REVIEW RESPONSE

DATE: 11-30-2021
PROJECT NAME: SHL20-044 & SEP20-023_ SUN
RESPONSE TO:
CITY OF MERCER ISLAND – PLANNING DEPARTMENT
9611 SE 36TH STREET
MERCER ISLAND, WA 98040-3732

This letter is in response to the corrections SHL20-044 & SEP20-023. Below are our responses to the questions/comments from September 9th, 2021.

SHEET NUMBER:
S 1

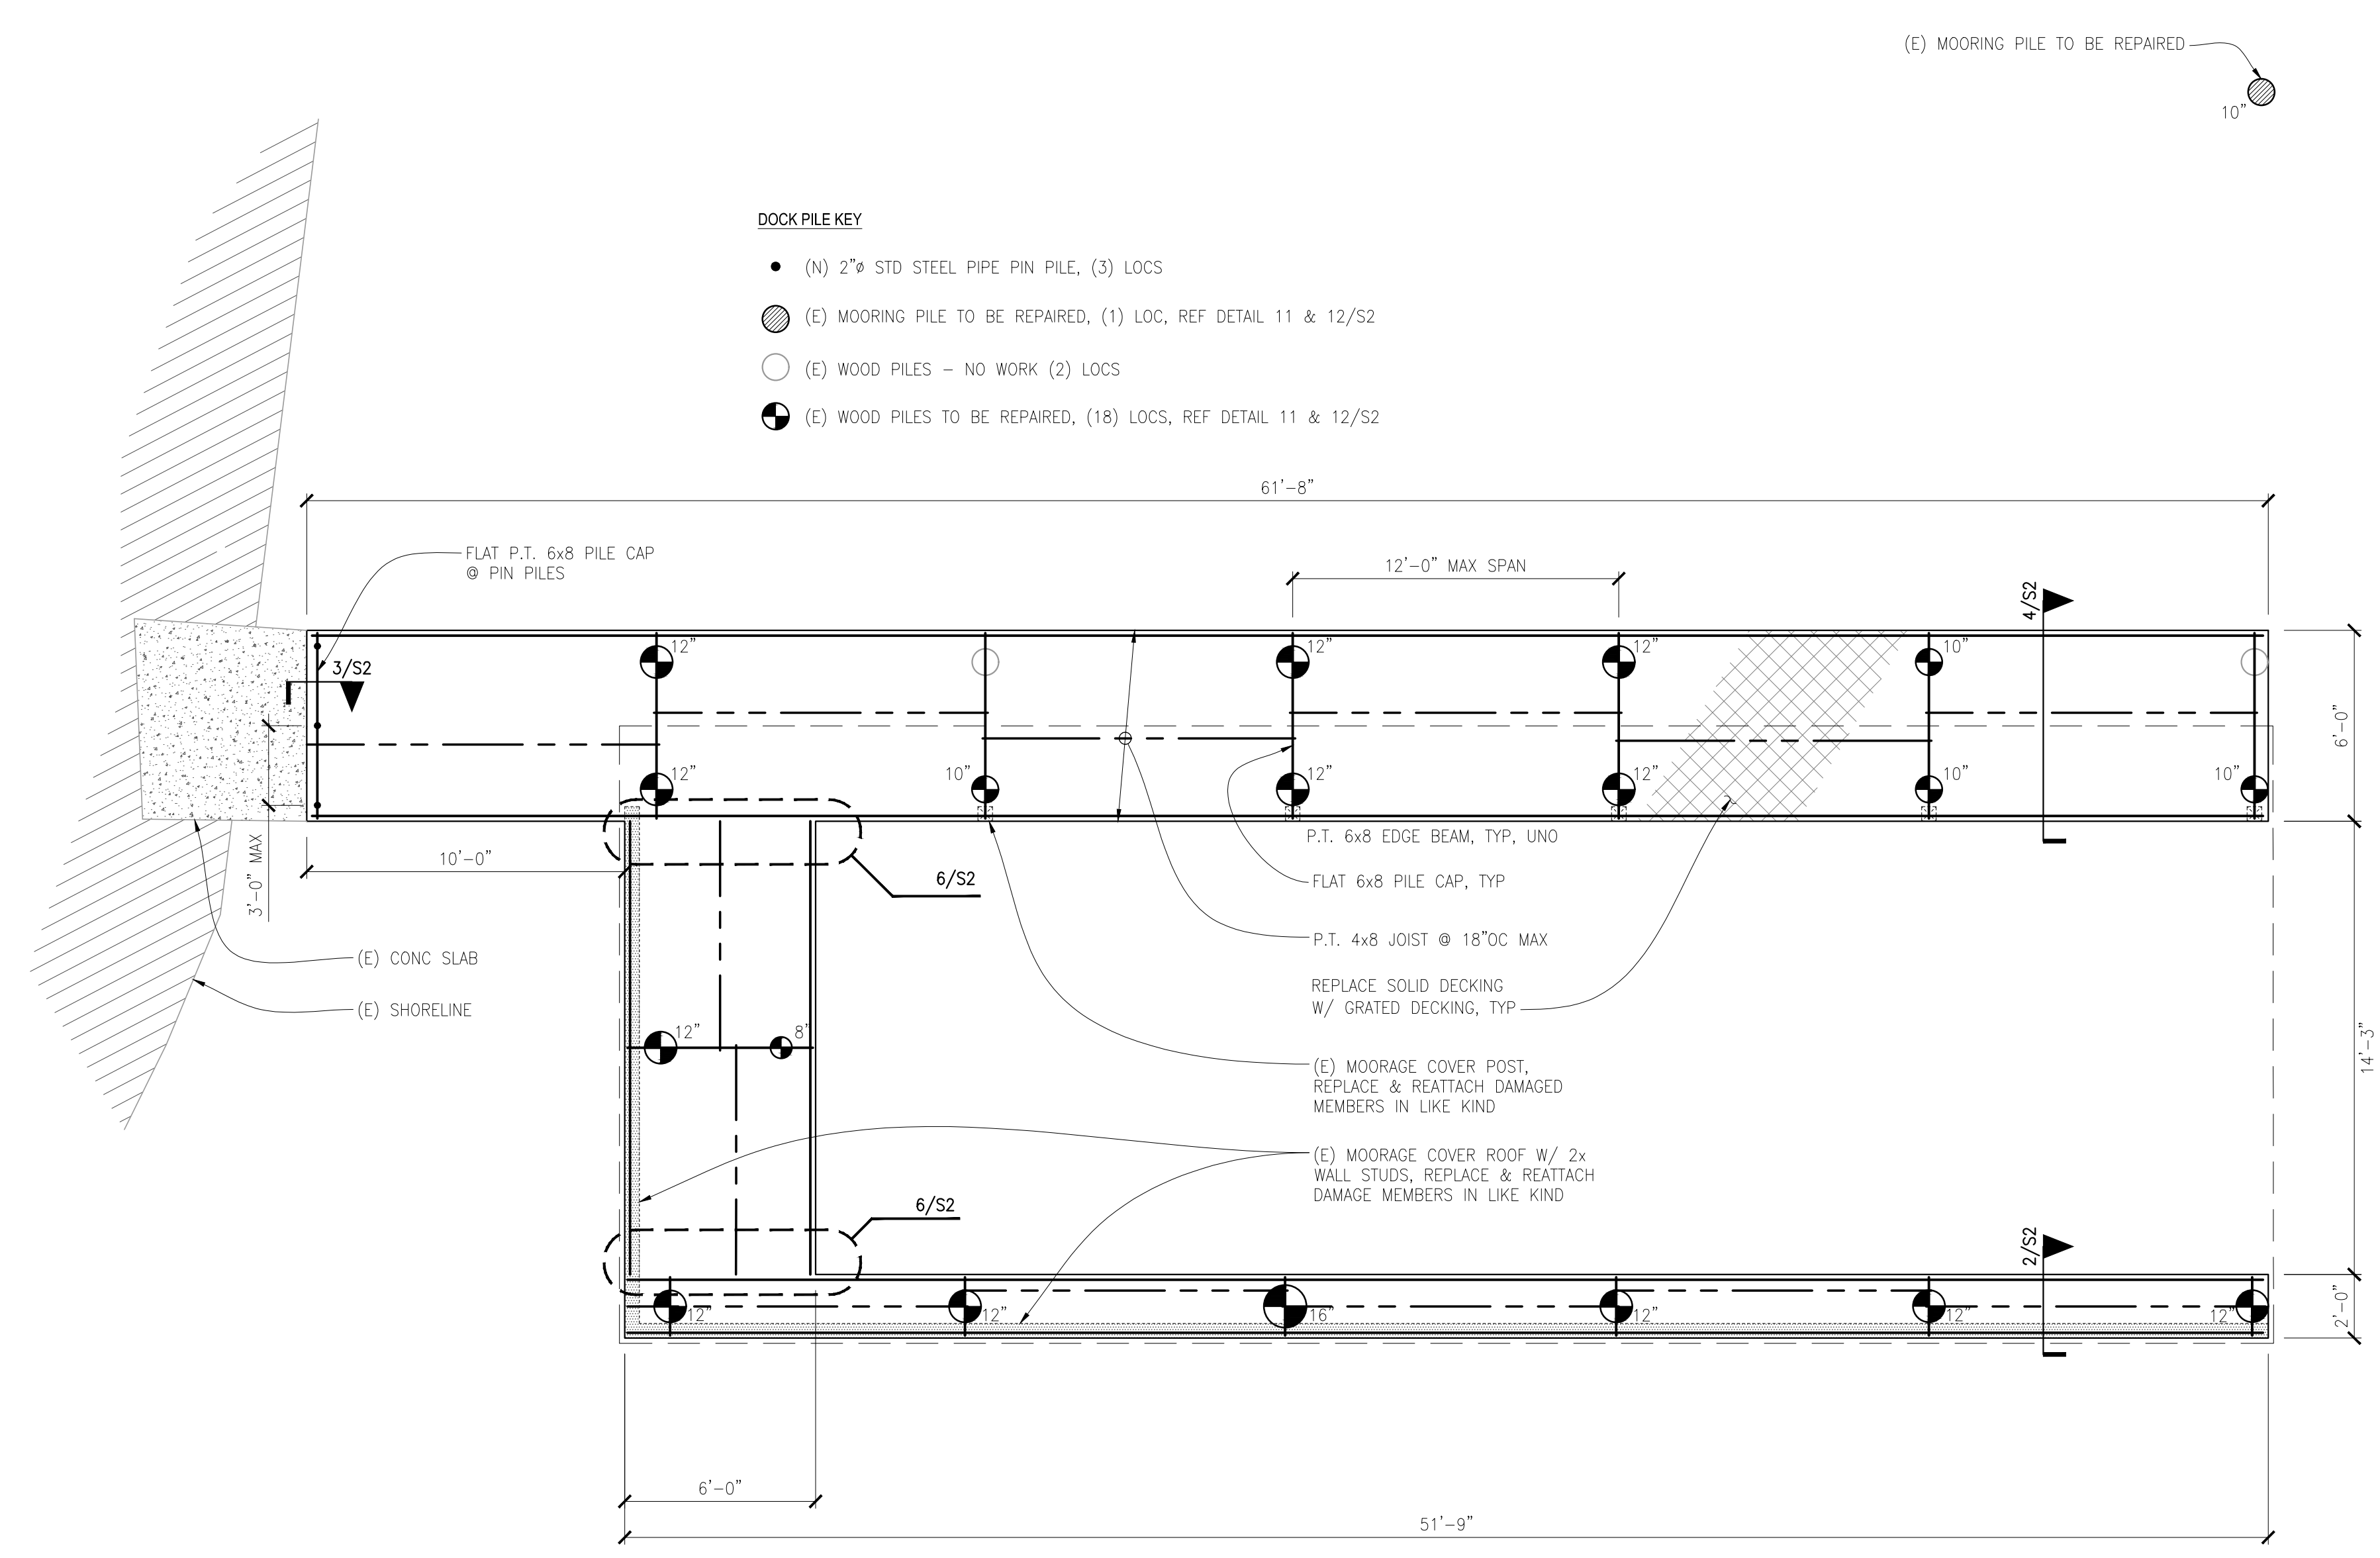
d. Sheet A4.0 shows that 10 of the existing piles will be repaired as part of this project. However, on sheet S1, it shows that 19 of the existing piles will be repaired. Please make sure that the proposed drawings are accurate and consistent.

Updated the plan set to show the member count for the dock on Sheet A4.0 which will allow us to repair (19) piles. I have updated the scope of work and the pile count legend to reflect this.
